Howerton Services, PLLC
License # P-1716
3513 Cathedral Bell Road
Raleigh, NC 27614
(919) 270-3460

Subject: 409 Lambert Lane
Fuquay Varina, NC 27526
Framing Inspection Letter
Harnett County Permit #: SFD2207-0020

Based on the request of the Contractor, I looked at 1 item from the framing inspection notice for code compliance. My assessment and recommendations are as follows:

**2ND FLOOR HEADER**  
**2ND FLR. CLG. FRAMING**

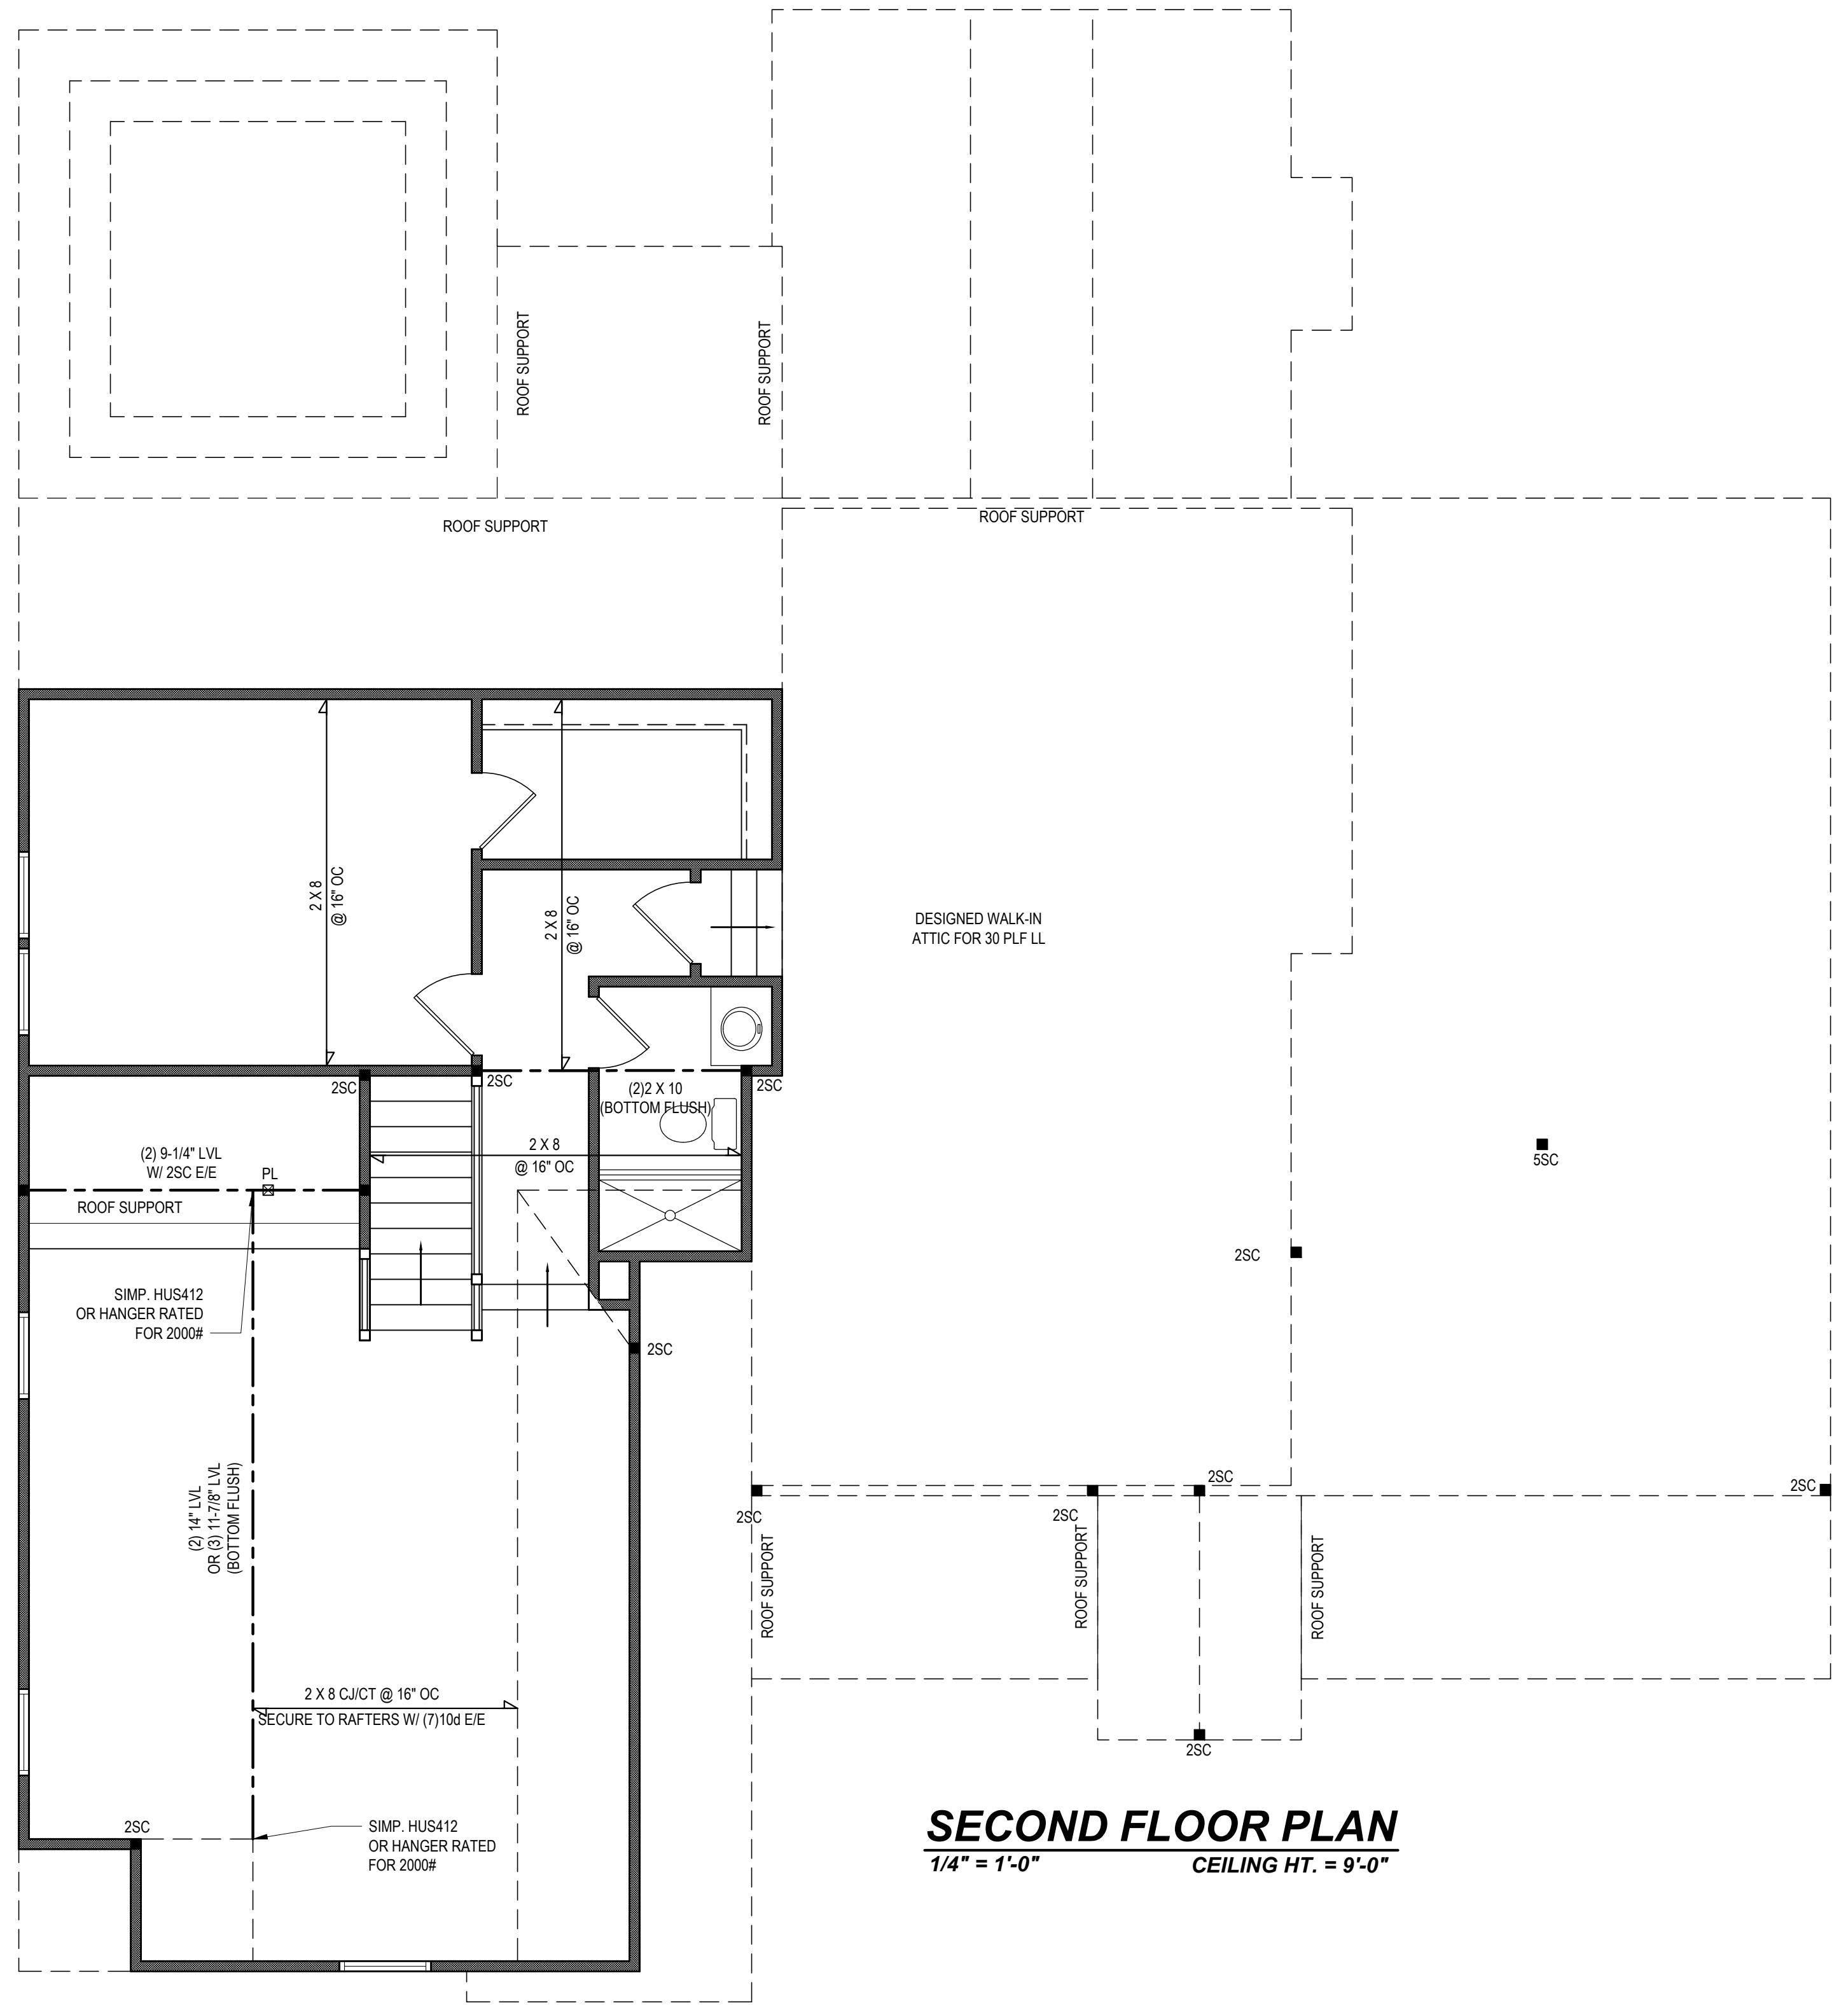
- The double 2x10 beam above the stairs to the 2nd floor was reduced to a double 2x6 beam. The double 2x6 beam is sufficient to carry the load from above.

The double 2x6 beam as installed meets all the requirements of the 2018 North Carolina Building Code for Residences.
